PALERANG COUNCIL

5 November 2010

Proposed Dargues Reef Gold Mine (PA10_0054) – Submission

Figure 4.11
NOISE MODELLING SCENARIO 2 -
OPERATIONS

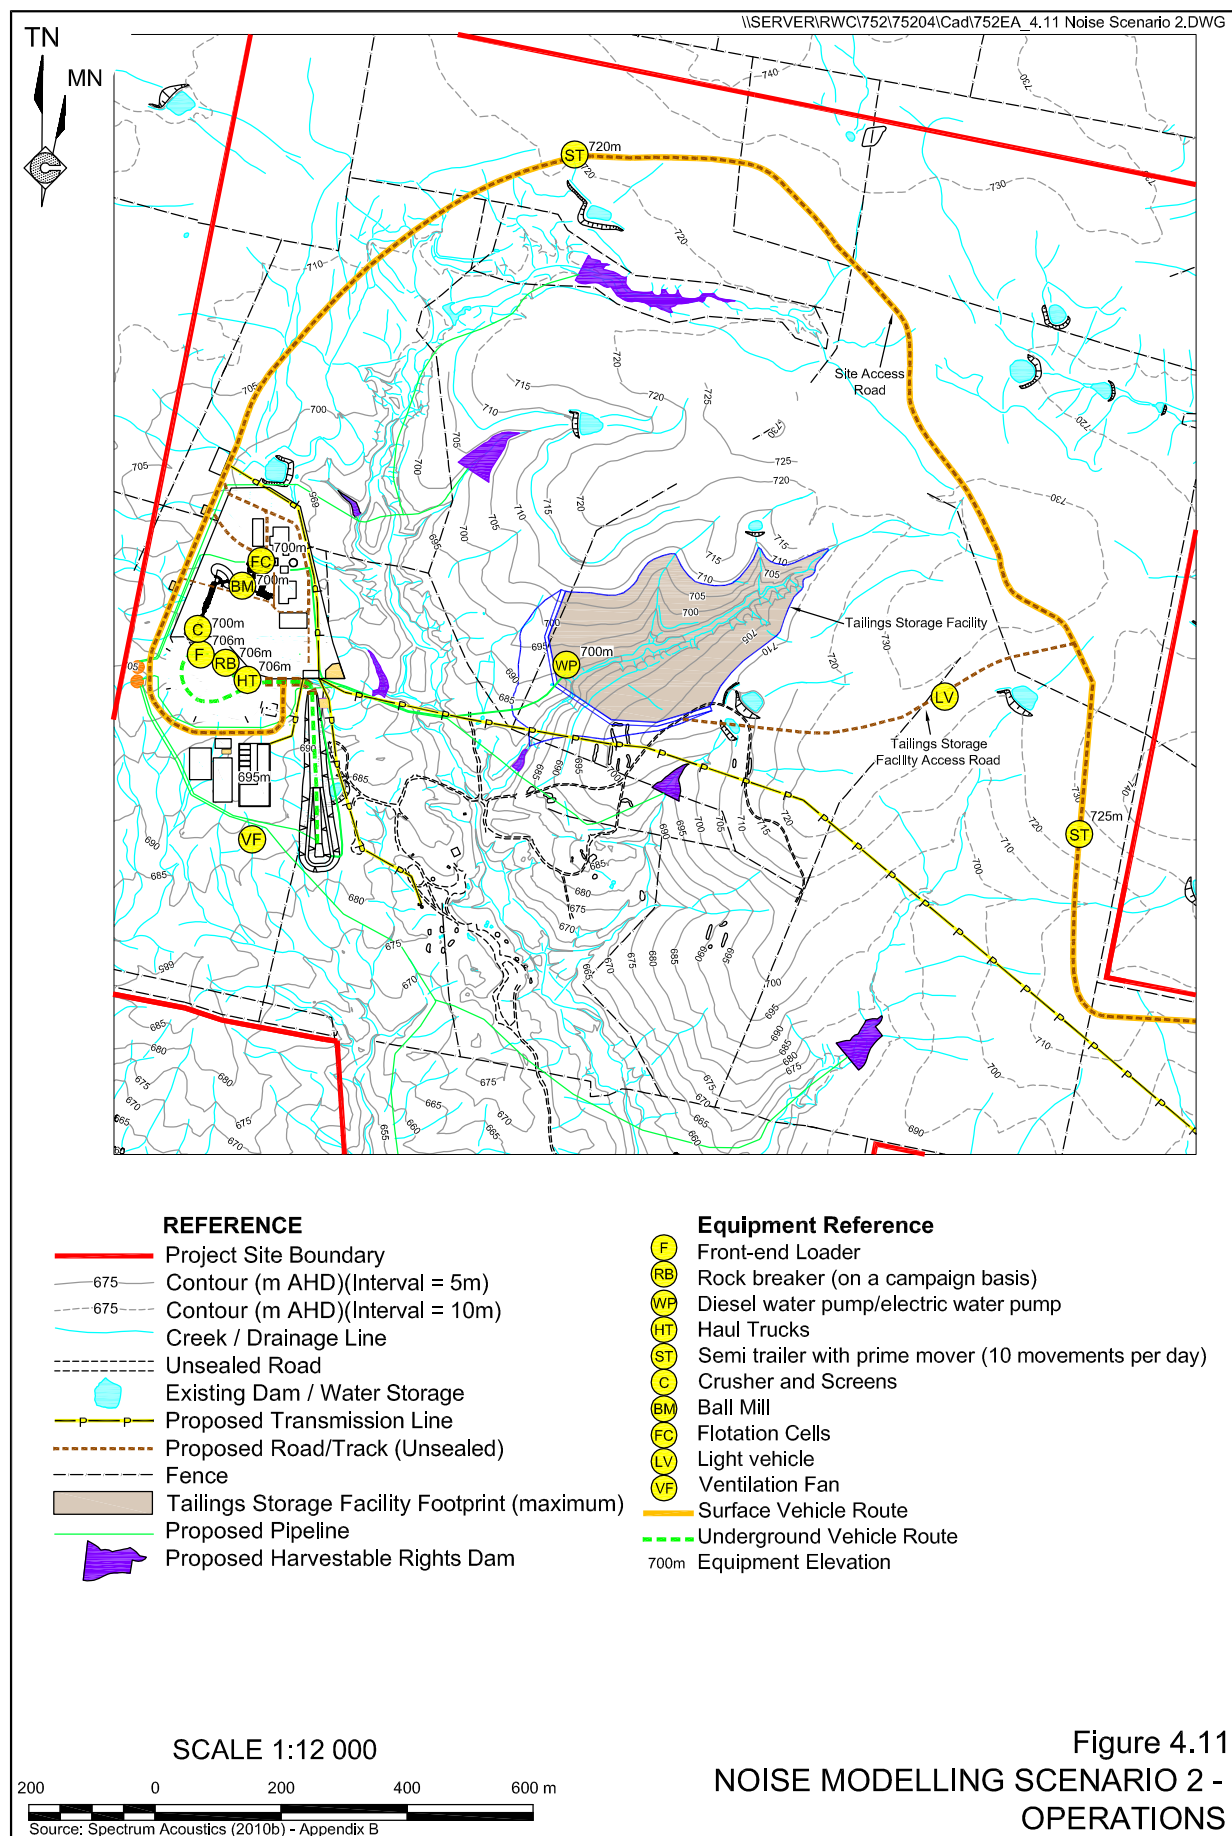
The environment surrounding the mine has an existing noise level below 30dB(A). The Guideline used to assess the impact of the proposed development on the surrounding area is the NSW Industrial Noise Policy (INP) produced by DECCW. The INP specifies two noise criteria – an intrusiveness criterion and an amenity criterion. Pg 4-29 of the EA states that only the intrusiveness criterion was considered in setting the project operational noise levels.

Whilst Council staff are concerned that the EA sets a sleep disturbance criterion of 45dB(A) when the existing background noise is 30dB(A). There appears to be an error in the report, as the maximum 45dB(A) which has been adopted for the EA was taken from Table 2.1 on page 16 of the INP, which relates to Amenity Criteria, which the EA states was not used as a criteria due to there being no existing major industry dominating noise levels at residences. Therefore staff consider that the appropriate noise level for evenings would be 35dB(A) (5dB(A) above normal background noise) as set on page 14 of the INP.

Table 4.10 of the EA has the predicted operational noise levels for a variety of residences in Majors Creek and all of them are over 35dB(A). Council, therefore, requests that the hours of operation be restricted as follows for the first full year of operation and further noise testing can be carried out to ensure that the night time disturbance meets the required dB(A). This precautionary approach would allow the mine to become operational and real data used to determine the noise levels, as opposed to the modelling contained within the EA.

- 6.30 am to 6.30 Monday to Friday
- 6.30am to 12.30pm Saturday,
- No work on Sunday.

13. Hours of operation (for above surface processing) will be 6.30 am to 6.30 Monday to Friday and 6.30am to 12.30pm on Saturday and no work on Sundays for the first full year of operation, to allow for real data to be used to determine the noise levels, dust and lighting interference that may occur, affecting the residents of Majors Creek and that the hours be reviewed at the end of this period.

Figure 4.33  
 EXISTING AVERAGE  
 DAILY TRAFFIC VOLUMES

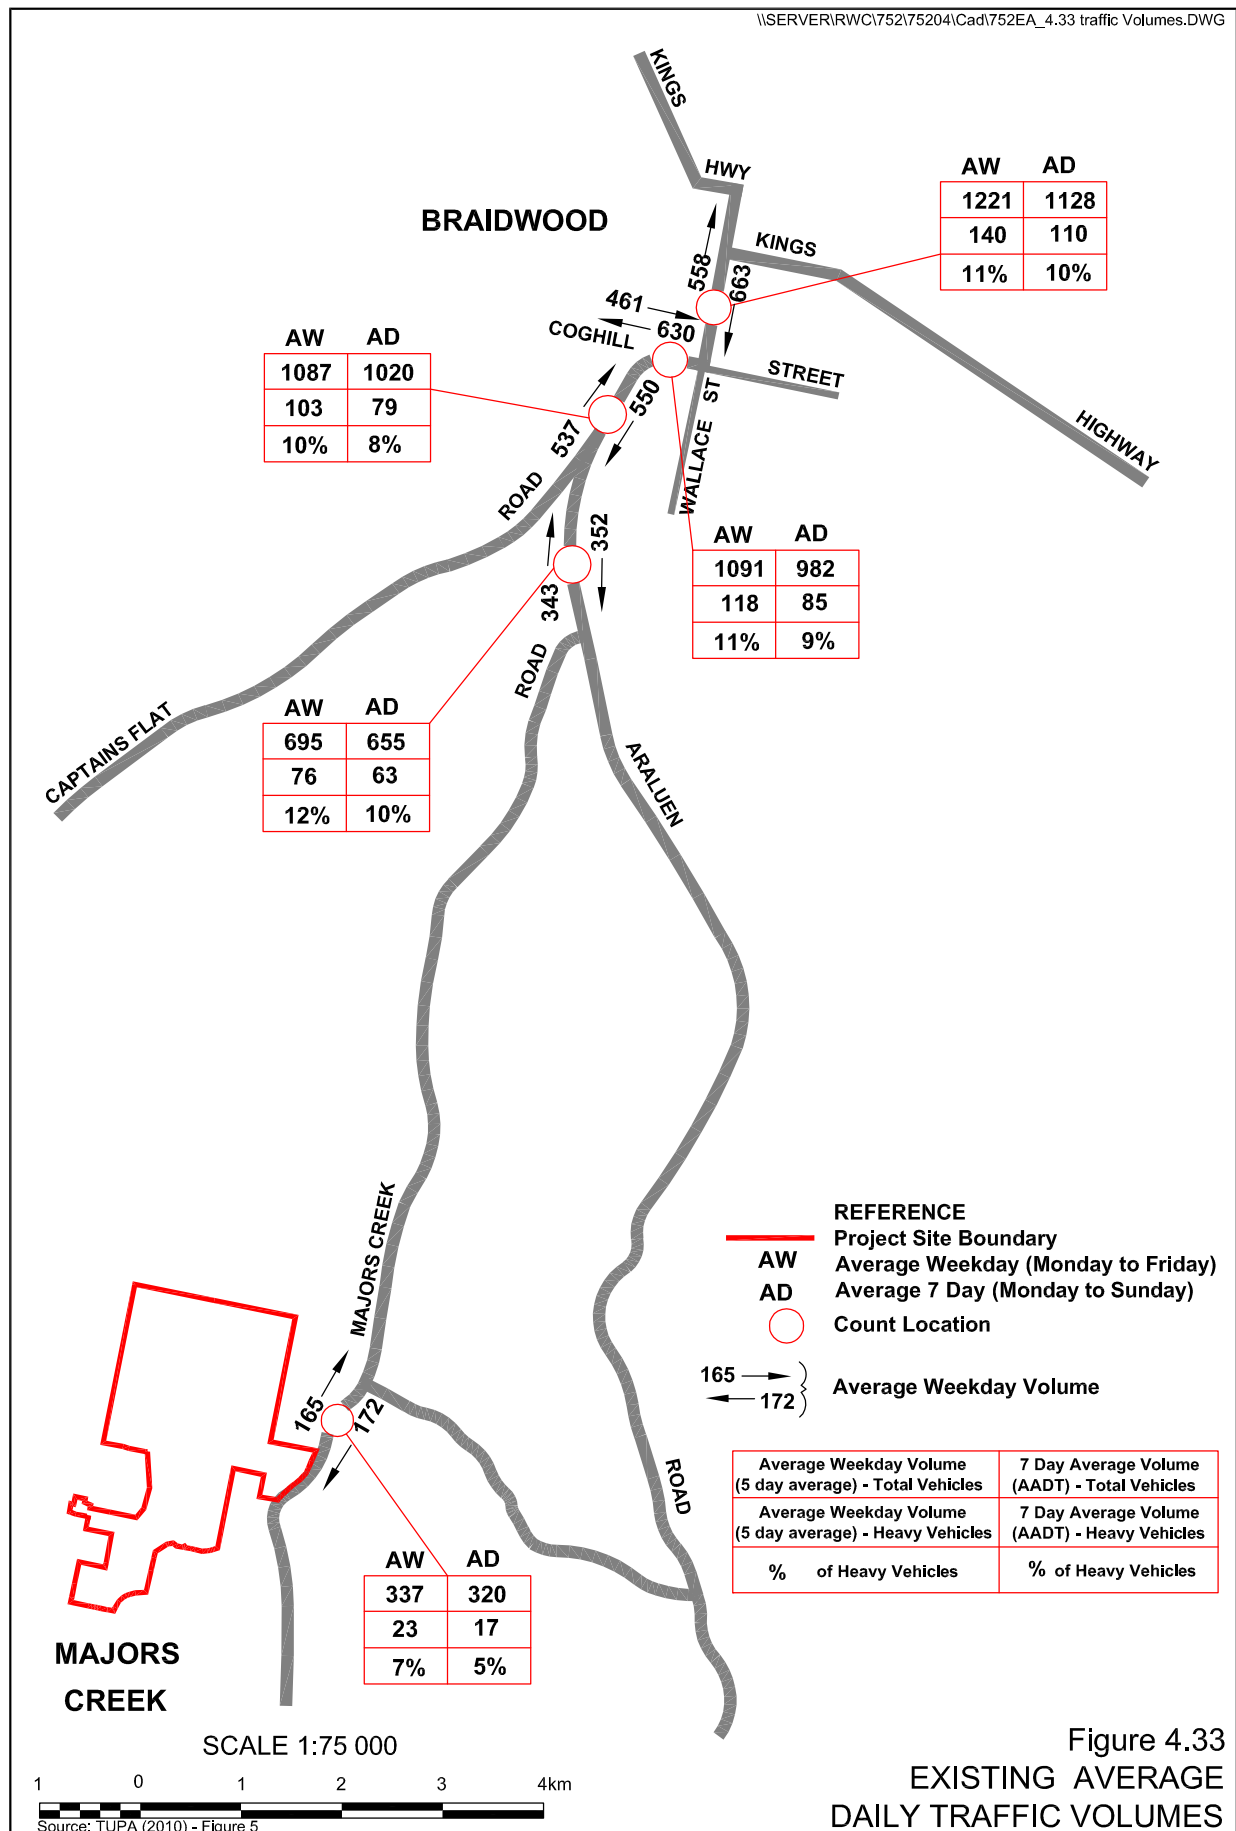
The traffic counts for the study were undertaken over a seven day period only which is not significant to draw accurate conclusions. There will be a significant increase in laden semitrailer movements on the route to and from the mine and this will have a significant impact on the roads leading to the mine, especially on Majors Creek Road. The passing of extra vehicles on the narrow crests and curves are a particular safety concern. The fairly light pavement of the road will also be damaged by the trucks delivering materials and plant to the mine and hauling the concentrate from the mine.

Council is satisfied that the applicant will address these issues by having agreed to enter into a planning agreement whereby Cortona will make payments to Palerang Council for it to

carry out necessary road upgrading and repairs to the pavement. See letter from Cortona dated 24 September 2010. A planning agreement is currently being developed between the parties. A condition of consent has been requested to achieve this.
